Final Report - Corrections Required **Application No. DEPN-25-0173**

Report Date: 06/02/2026

Document Filename : V3. Development Plan_Rock Creek.pdf

SHEET 25 OF 41

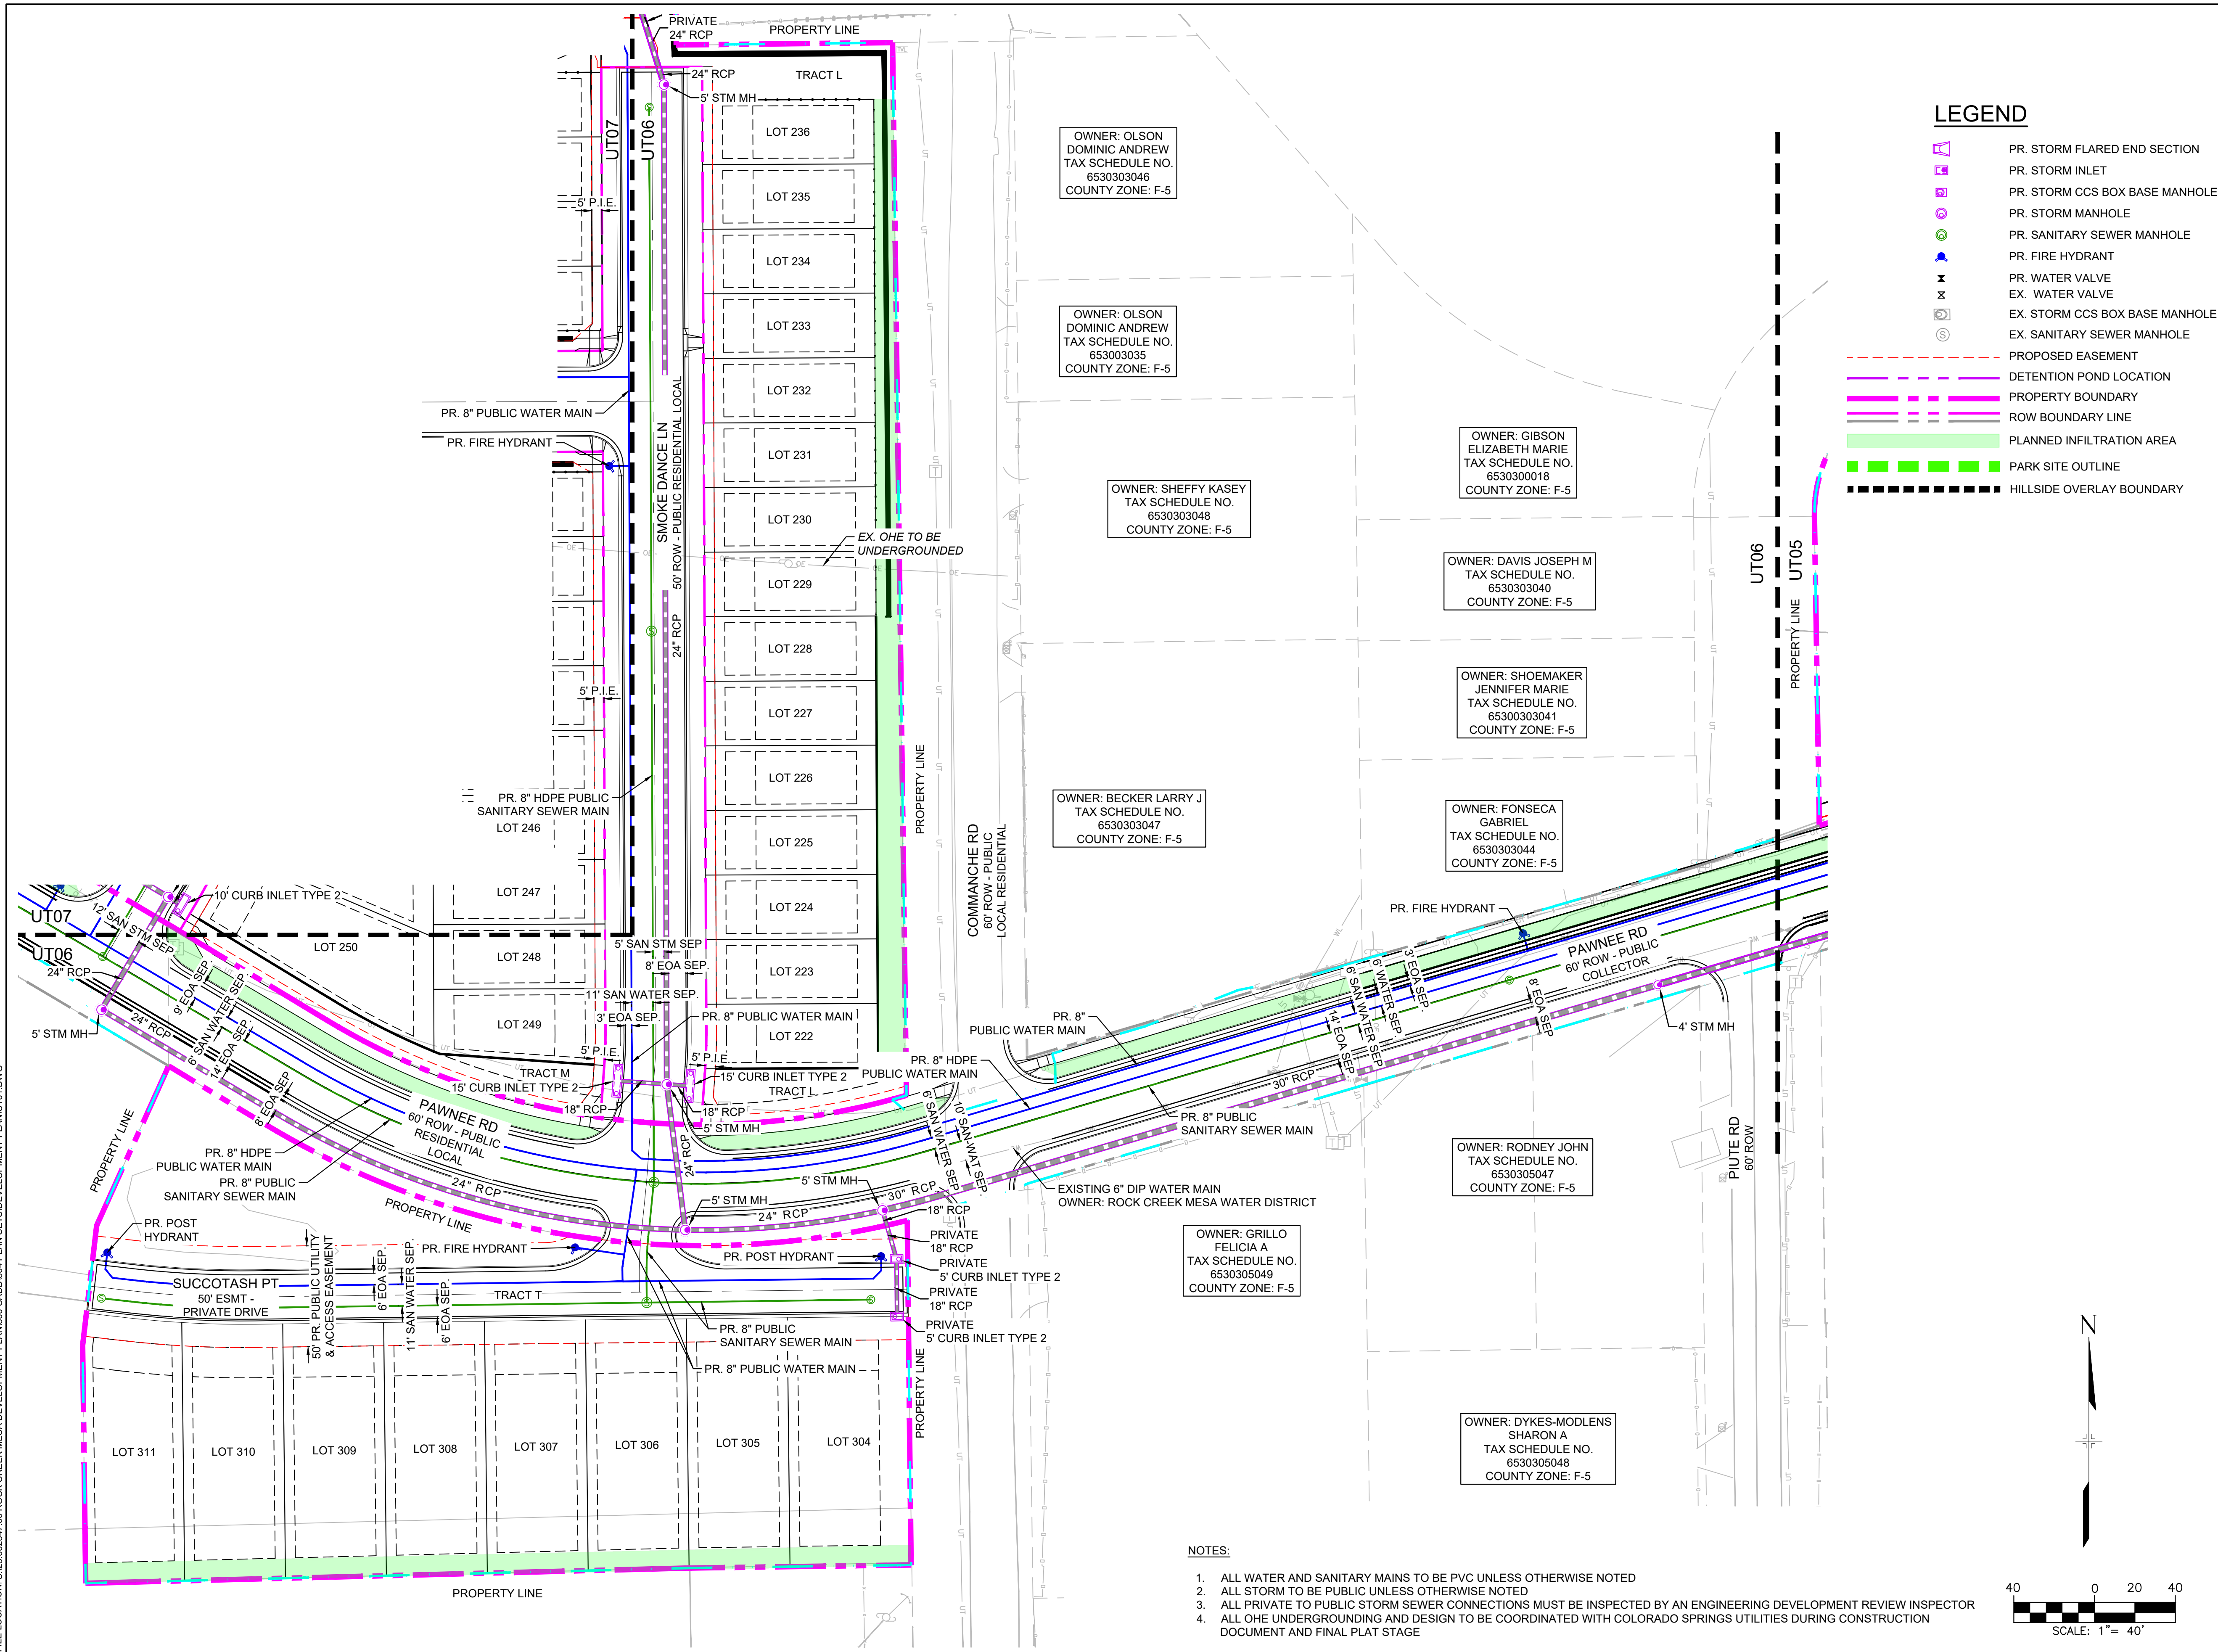
Comment ID	Page Reference	Reviewer : Department	Review Comments
278	25	Patrick Dosch : Col Springs Utilities	Label the horizontal separation from the water and storm inlet
279	26	Patrick Dosch : Col Springs Utilities	Label horizontal separations in this area
280	27	Patrick Dosch : Col Springs Utilities	Label horizontal separation
281	27	Patrick Dosch : Col Springs Utilities	Revise line work to show water and wastewater with at least 10' horizontal separation or indicate HDPE
293	9	Steve Smith : Fire	Must be a paved
294	9	Steve Smith : Fire	Provide full access with curb returns at both ends. No mountable curbs.
295	9	Steve Smith : Fire	Provide dimension of driveable width
296	9	Steve Smith : Fire	Removable bollards not permitted in this location. Must be a gate the full width of the drive.
297	40	Steve Smith : Fire	Must be minimum full width of the drive. Provide Fire Lane No Parking sign with dual arrows on the gate.

LP2.01
 32 OF 41

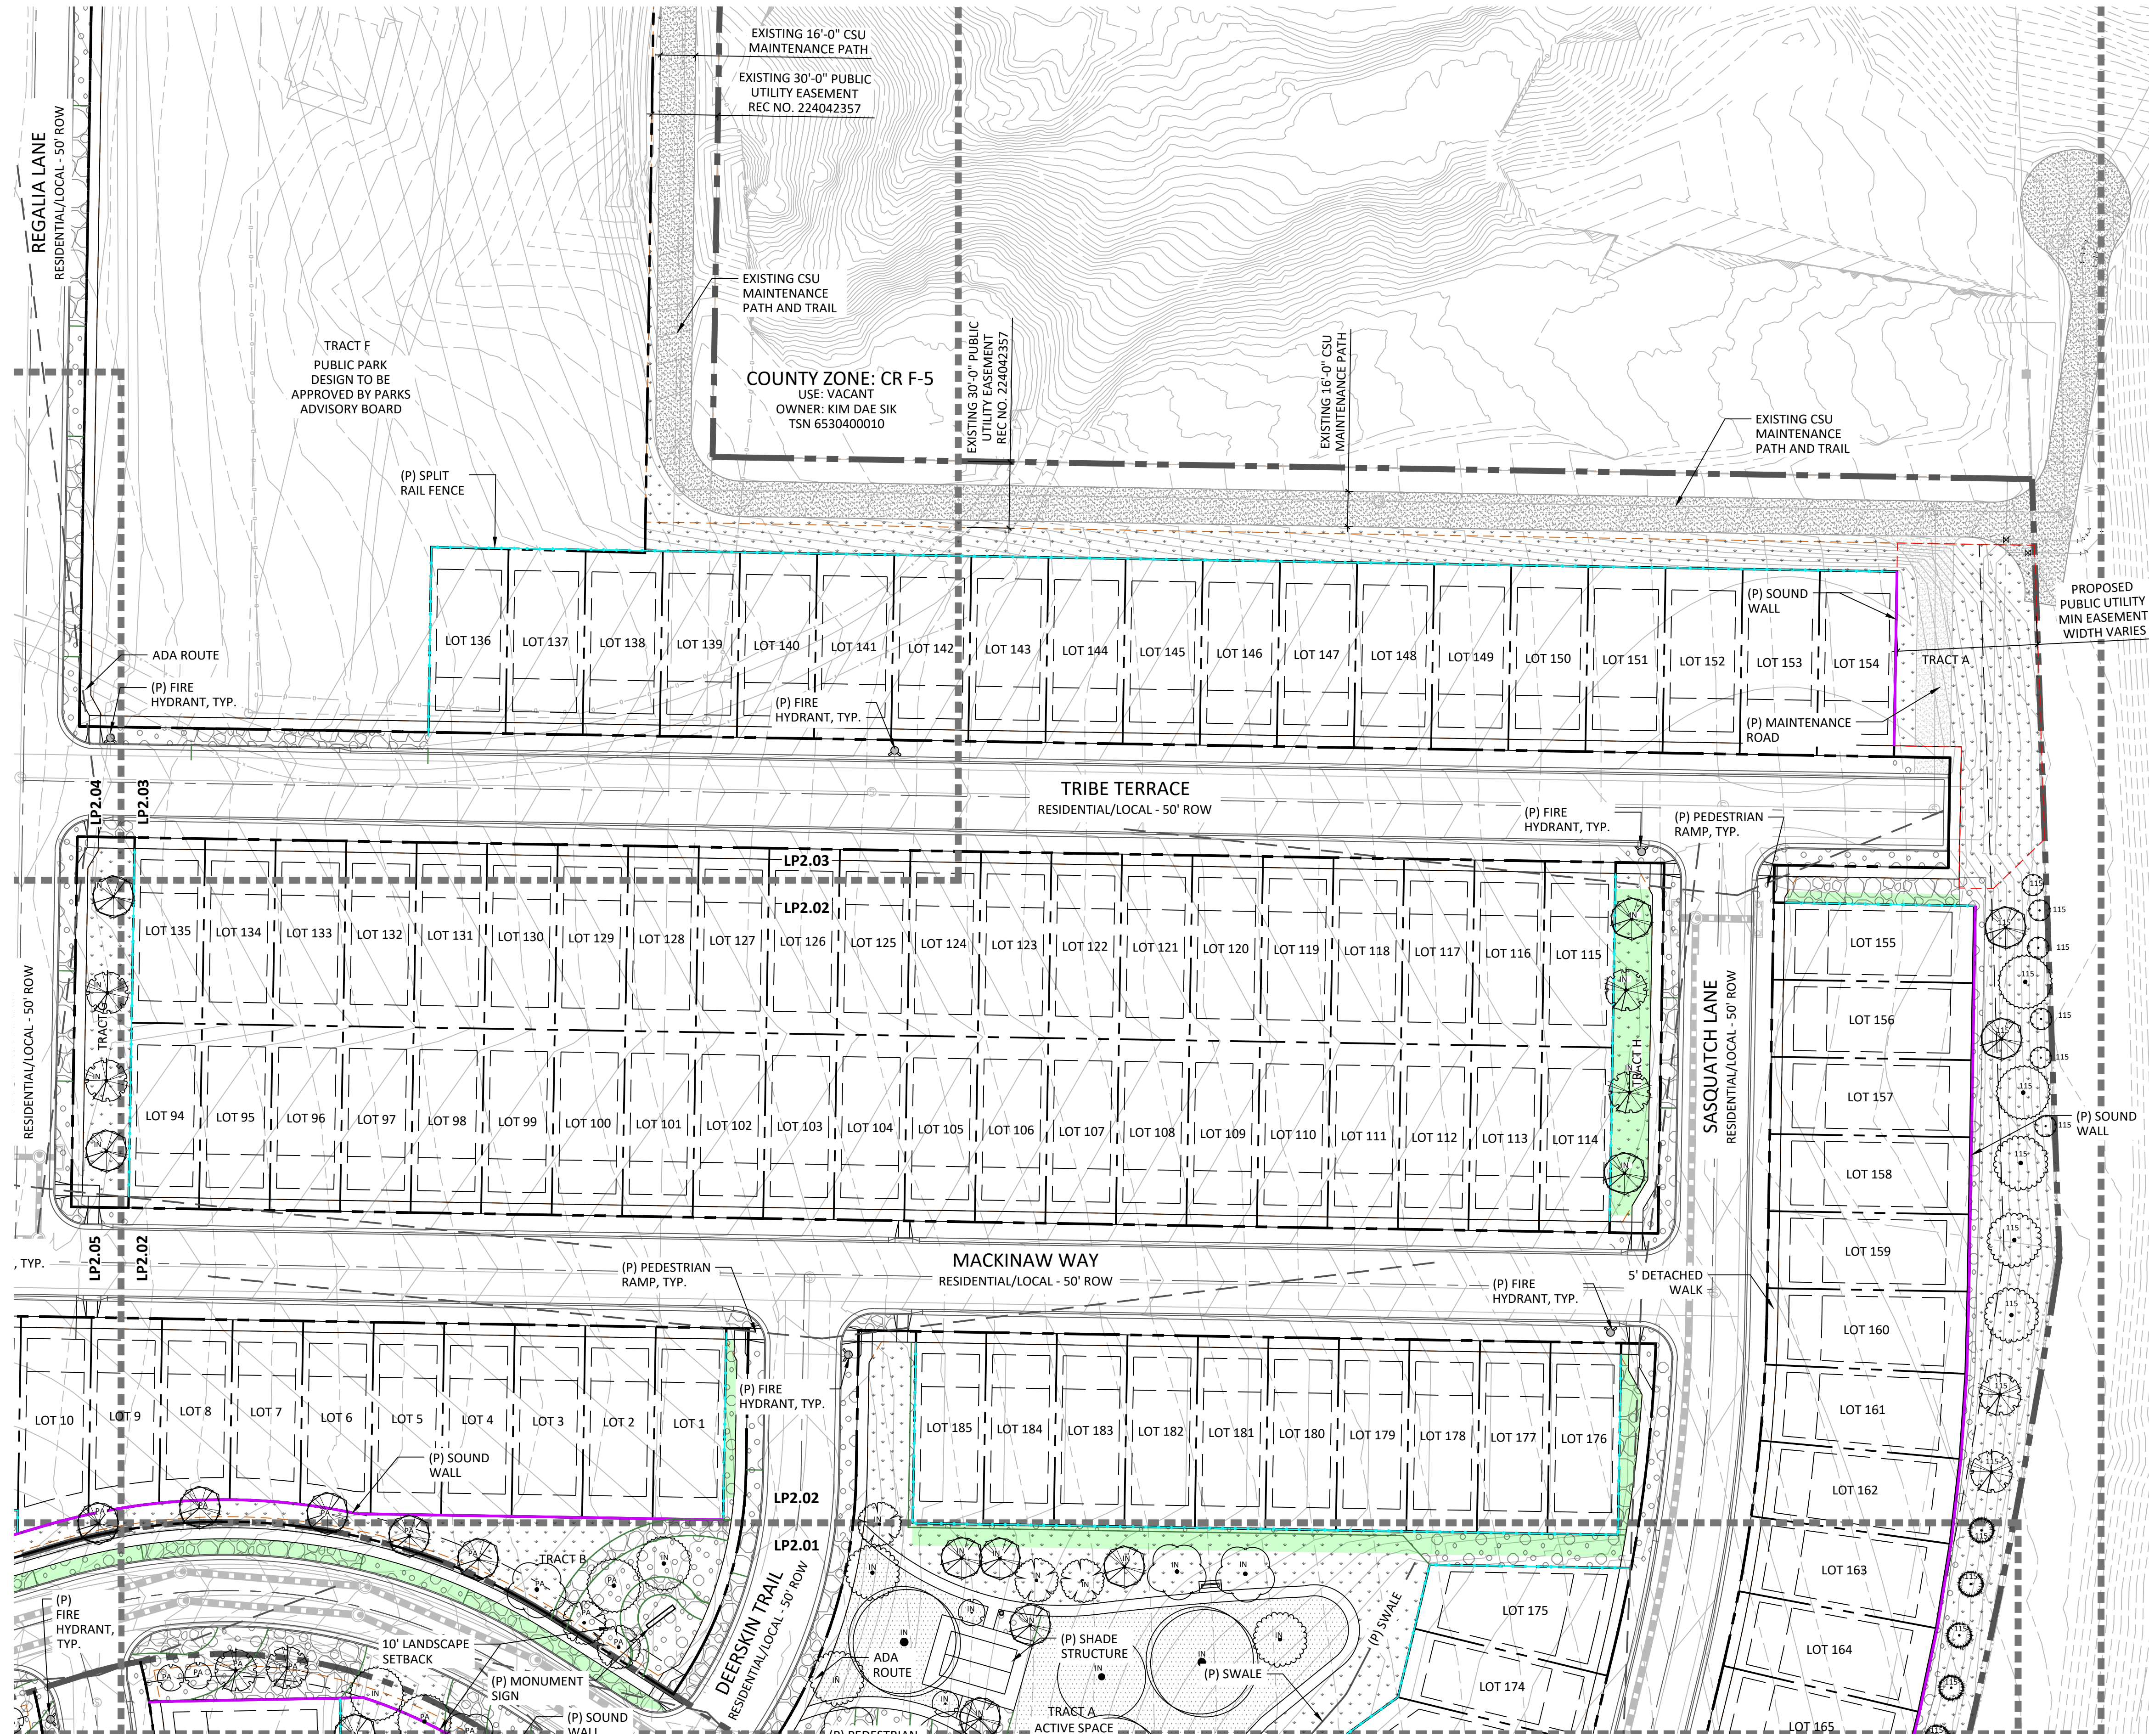
55	32	Sara Rivera : City Engineering - SWENT	All proposed swales must be shown and labeled on landscape plans. Please show how proposed landscaping will interact with proposed conveyance swales.
56	32	Sara Rivera : City Engineering - SWENT	Please show and label all private and public easements as applicable on all sheets.
269	32	Sara Rivera : City Engineering - SWENT	Specifically label the swales on the landscape plan; review the FDR to label correctly on this plan.
213	1	Joel Dagnillo : City Engineering Dev Review	See previous comment: "Geological hazard validation has been submitted in Project Dox (#STM-REV26-0208) and is currently under review. All comments will be communicated directly in Project Dox. Once all comments are addressed and City approves validation, upload City-signed validation into this Development Plan file."
265	3	Joel Dagnillo : City Engineering Dev Review	Engineering Criteria Manual Variance request for omitting sidewalk on south side of Pawnee Rd. has been denied (STM-REV26-0431). Please show 5' detached sidewalk on south side of this roadway.
